**Howerton Services, PLLC**  
**License # P-1716**  
3513 Cathedral Bell Road  
Raleigh, NC 27614  
(919) 270-3460

Subject: Hobbs Residence  
99 Kipling Road  
Fuquay Varina, NC 27526  
Plan Revision Letter  
Harnett County Permit #: SFD2202-0069

Based on the request of the Contractor, several items on Sheet S2 were revised. My assessment and recommendations are as follows:

**S2** FIRST FLOOR FRAMING  
**01** 1/4"=1'-0"

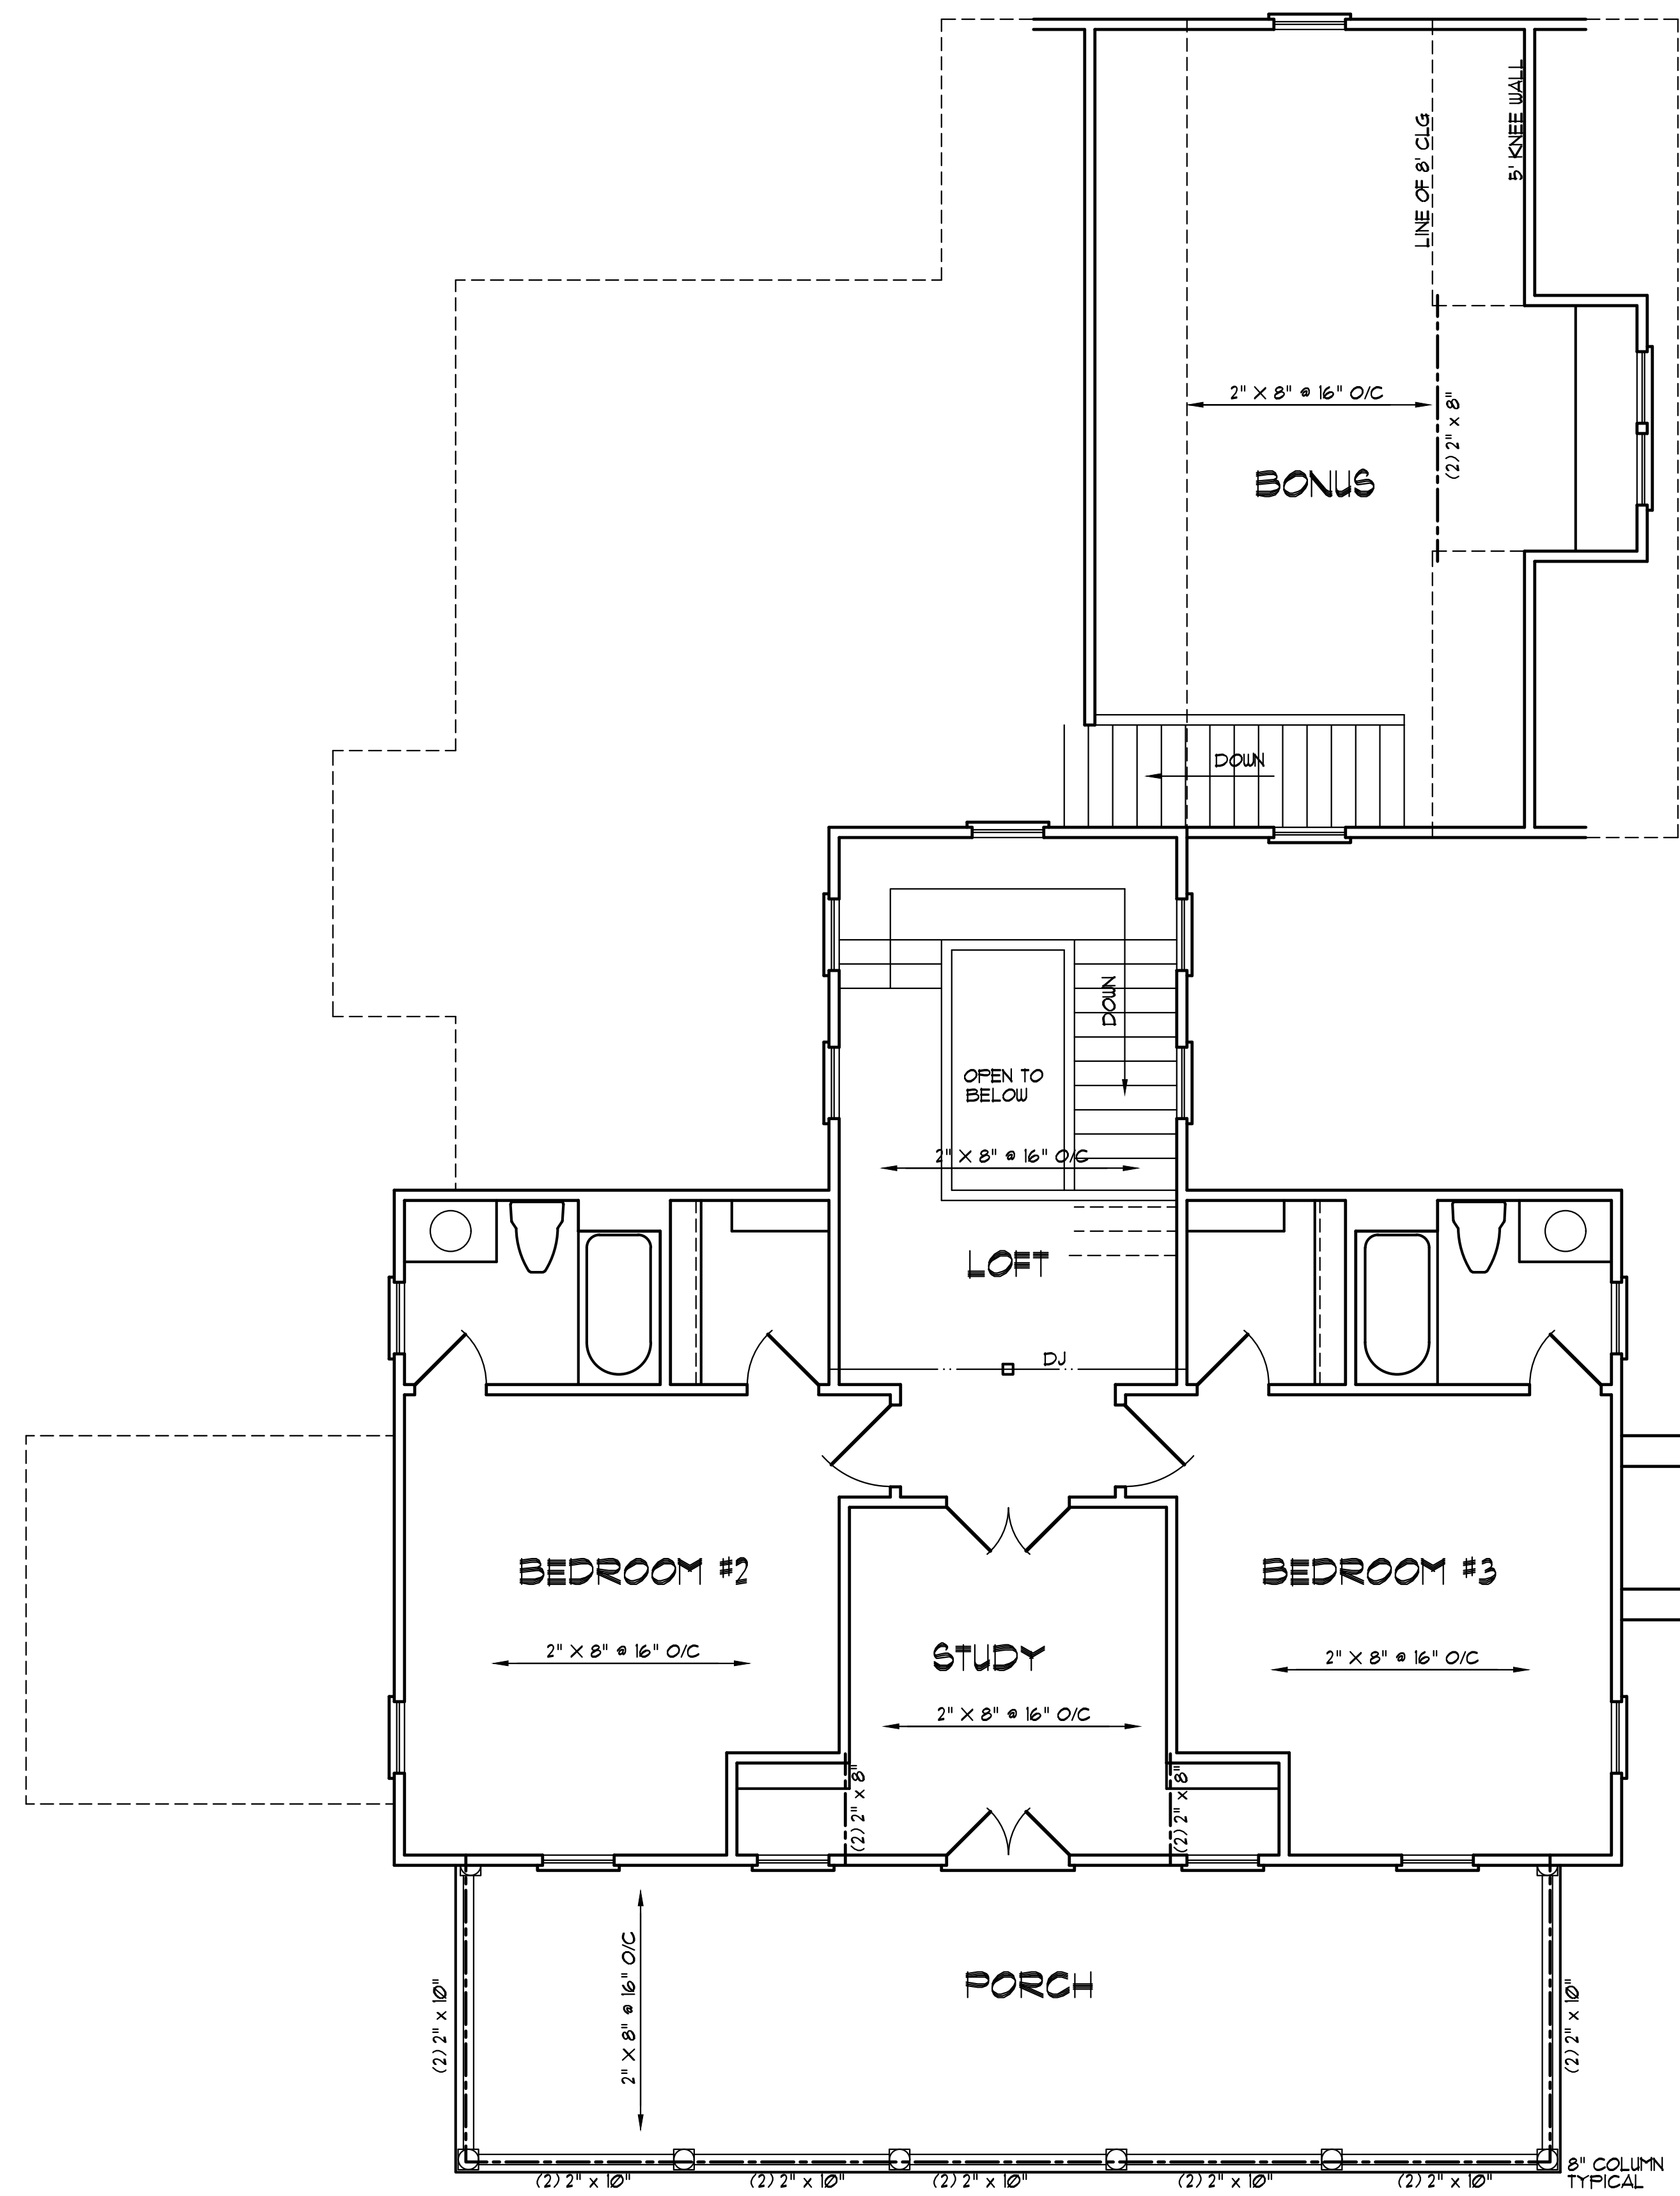
- The I-joists over the Kitchen and Family Room were changed. The new joists are 14" BCI 5000s 1.8 spaced at 16" centers. The LVL beams in this location were changed to double 1 3/4"x 14" LVL beams.

- The I-joists over the Garage were changed. The new joists are 14" BCI 5000s 1.8 spaced at 12" centers. The LVL beam at the Garage steps was changed to a double 1 3/4"x 14" LVL.

- The LVL beams supporting the stairway and the stairway landing to the 2<sup>nd</sup> floor of the main living space were changed to double 2x10s.
- The orientation of the stairs to the space above the Garage was modified. The stair landing at the midpoint of the stairs will be supported by 4x4 diagonal members or 2x4 stud wall with Simpson CS16 straps supporting the end closest to the overhead Garage Doors. The joists over the Garage at the stairs will be 2x10s spaced at 16" centers and double 2x10 beams.

- The header over the 2<sup>nd</sup> floor door onto the front porch balcony will be a double 2x8.

The revised items noted above meet all the requirements of the 2018 North Carolina Building Code for Residences.
